From: Edward Hines [REDACTED]
Sent: 29 July 2022 11:54
To: Anita Gardner <Anita.Gardner@arun.gov.uk>
Subject: RE: A/70/22/CLE- Arundel Acre

From: Anita Gardner
Sent: 25 July 2022 09:53
To: Joney Ramirez [REDACTED]
Subject: A/70/22/CLE- Arundel Acre

ARUNDEL ACCE	
ARUNDEL RD	
ANNE MOUNTAIN SUSSEX	
SCALE 1:500 METRES

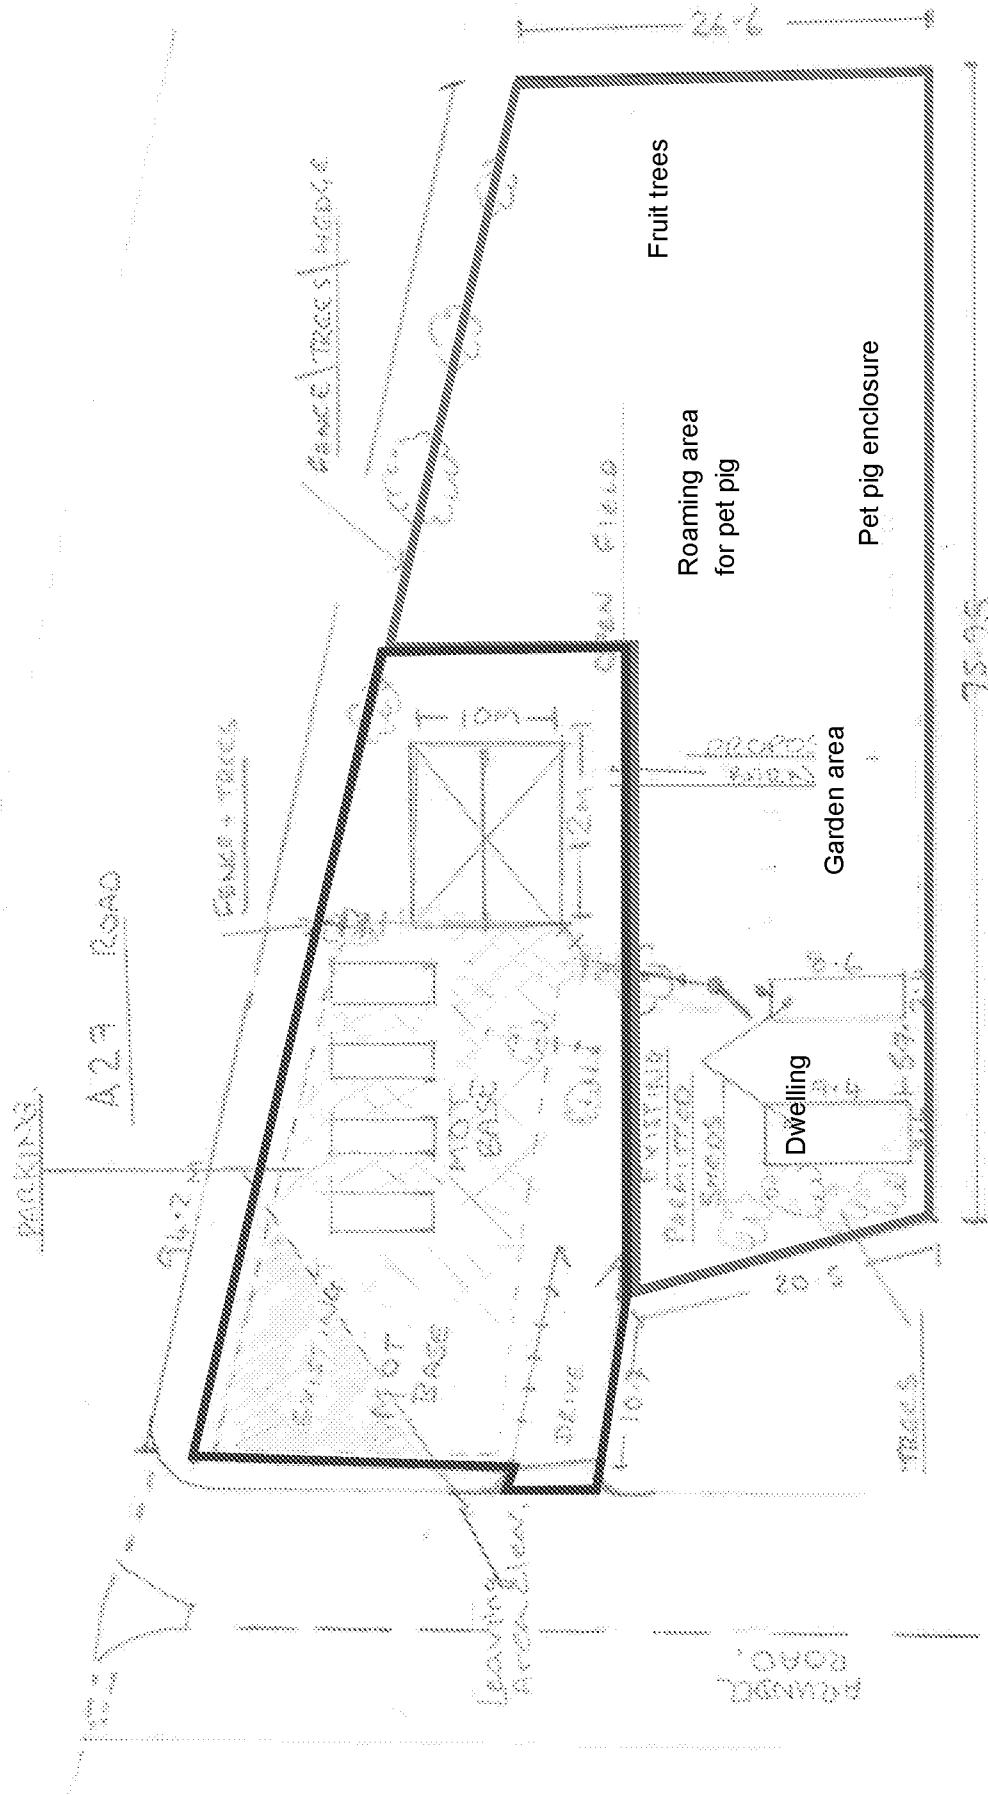
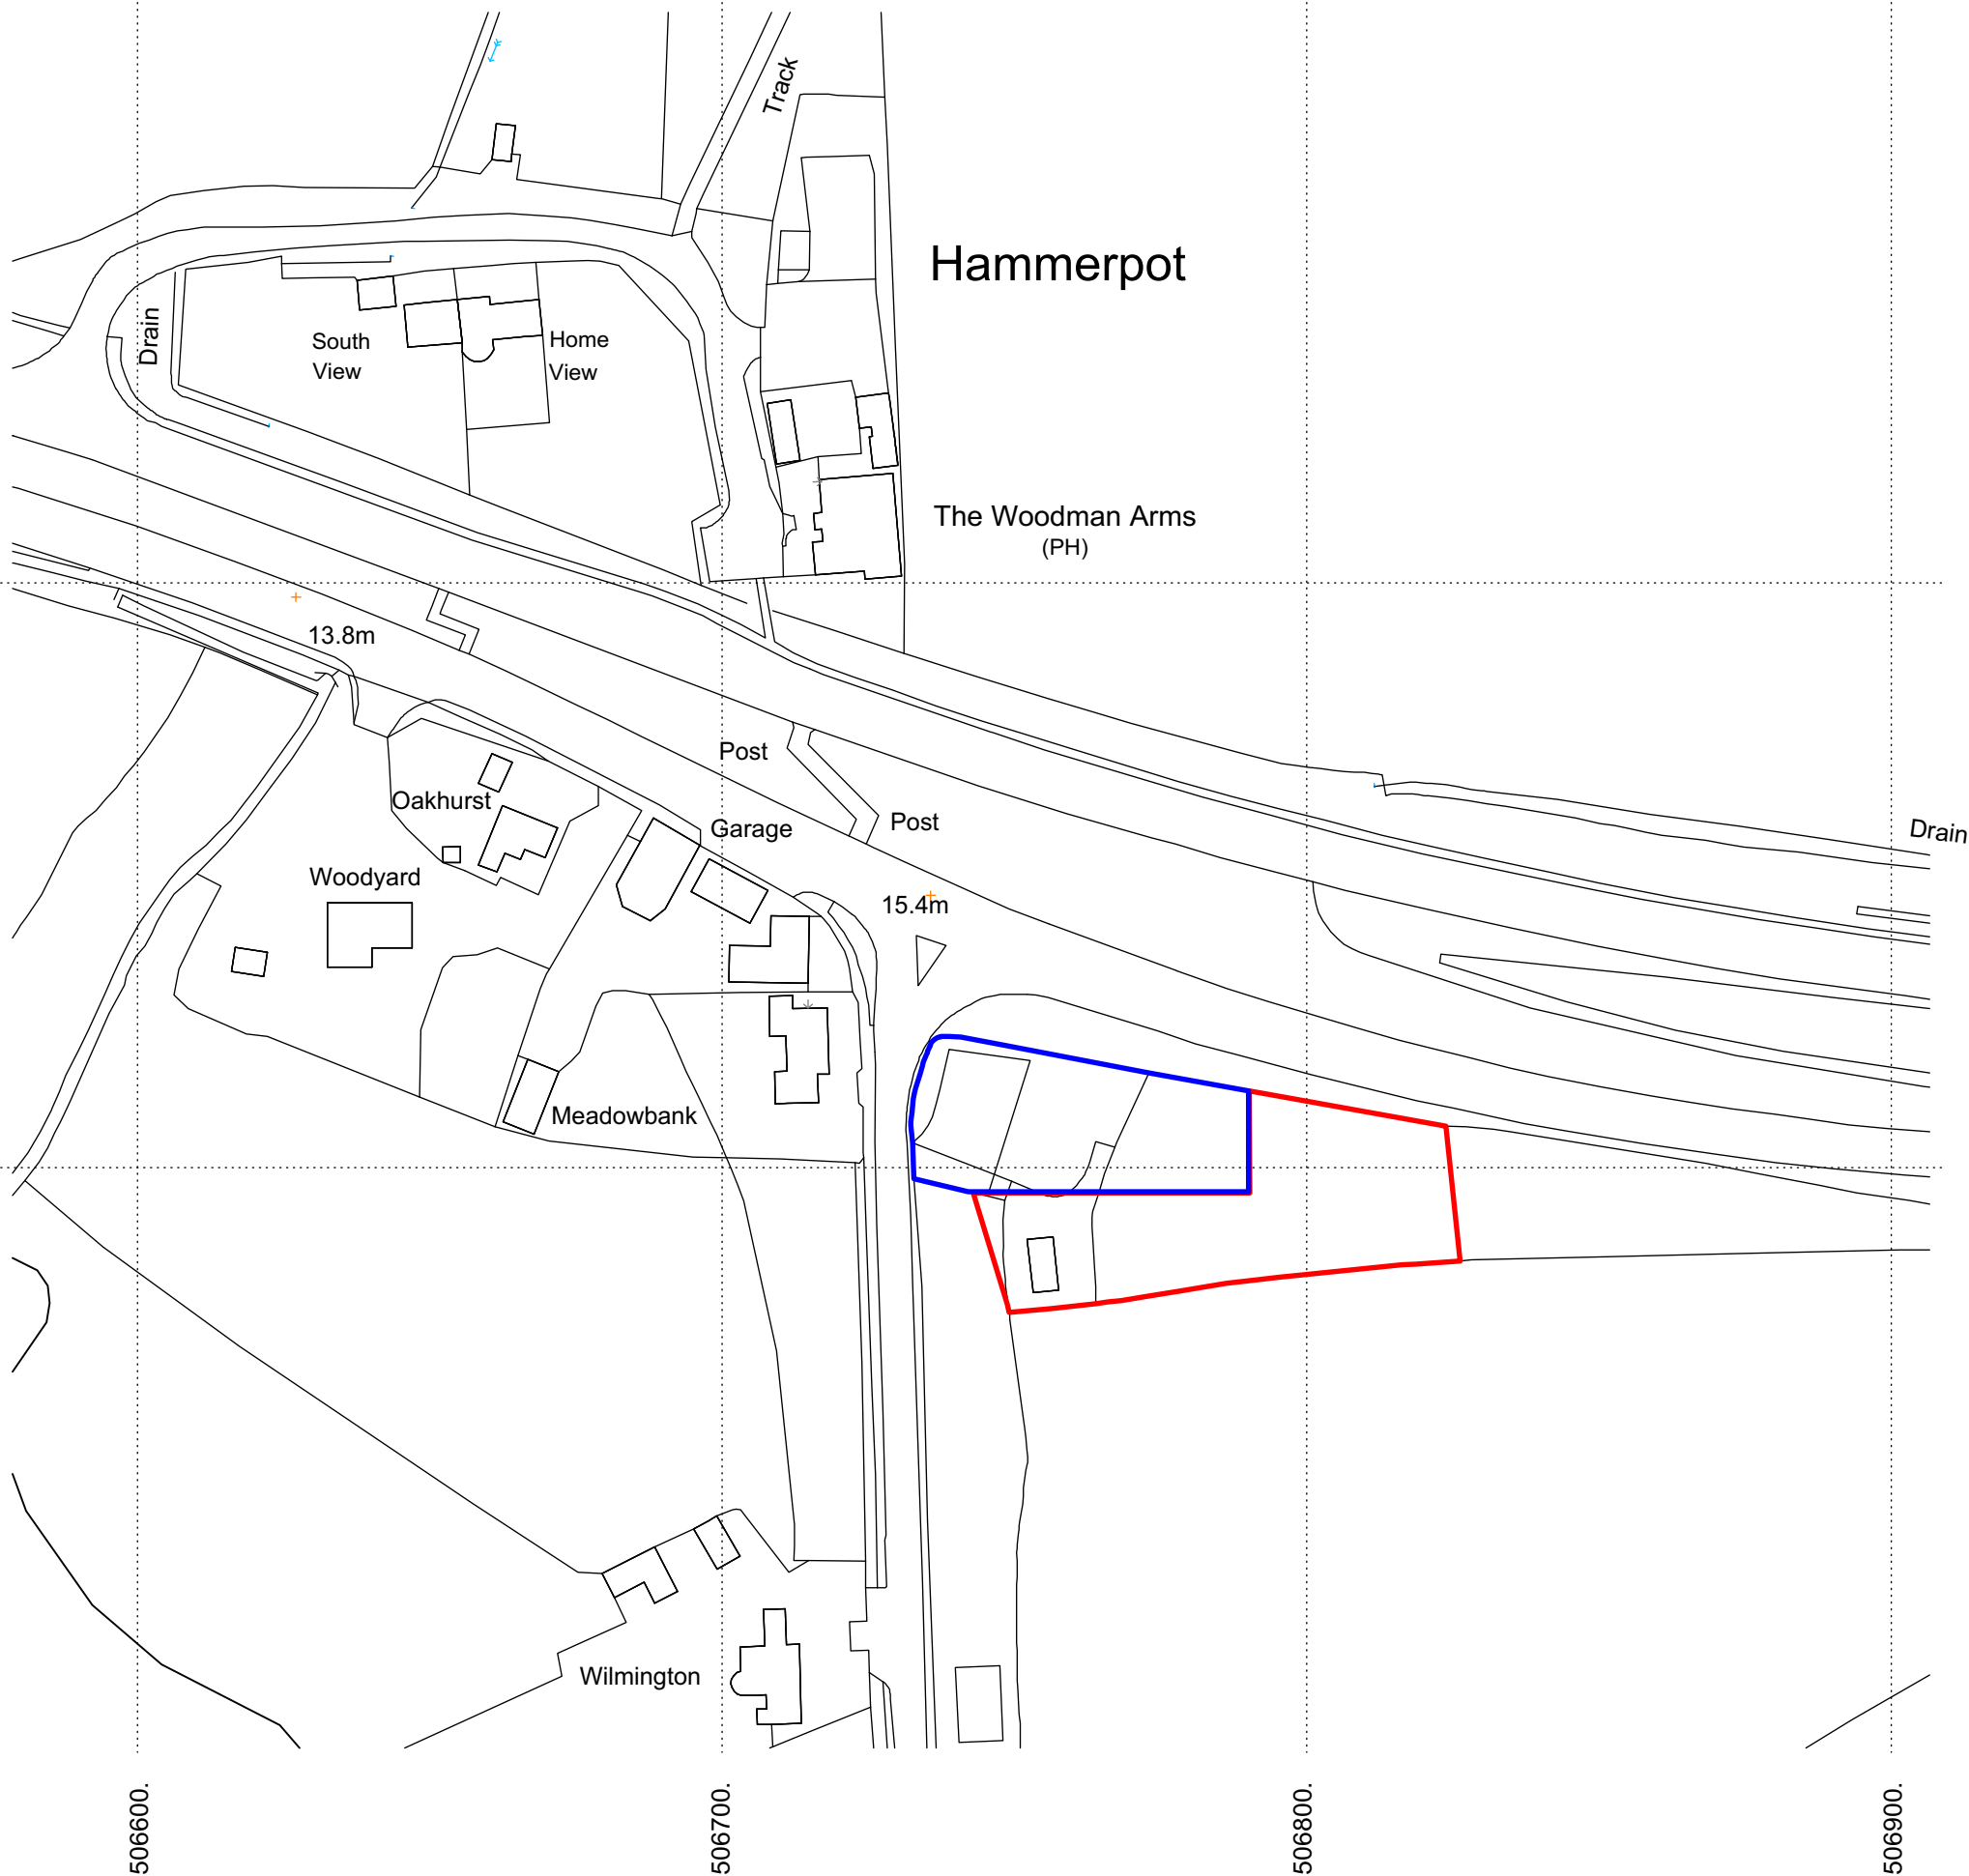
I am currently going through the evidence submitted with your application and note that there is no mention of the area of fruit trees being used as part of the dwelling within the statements or photographs and I am therefore querying whether the red edge should be reduced accordingly.

I also note that the red edge indicated does not correlate with our Arun Mapping system. The dwelling is shown parallel with the curtilage and the boundary is straight and I believe it is angled slightly. Can you please let me have a more accurate plan that correlates better with our mapping system since I want to ensure the Plan produced accurately reflects the area you have indicated. Could you provide a plan based on our system?
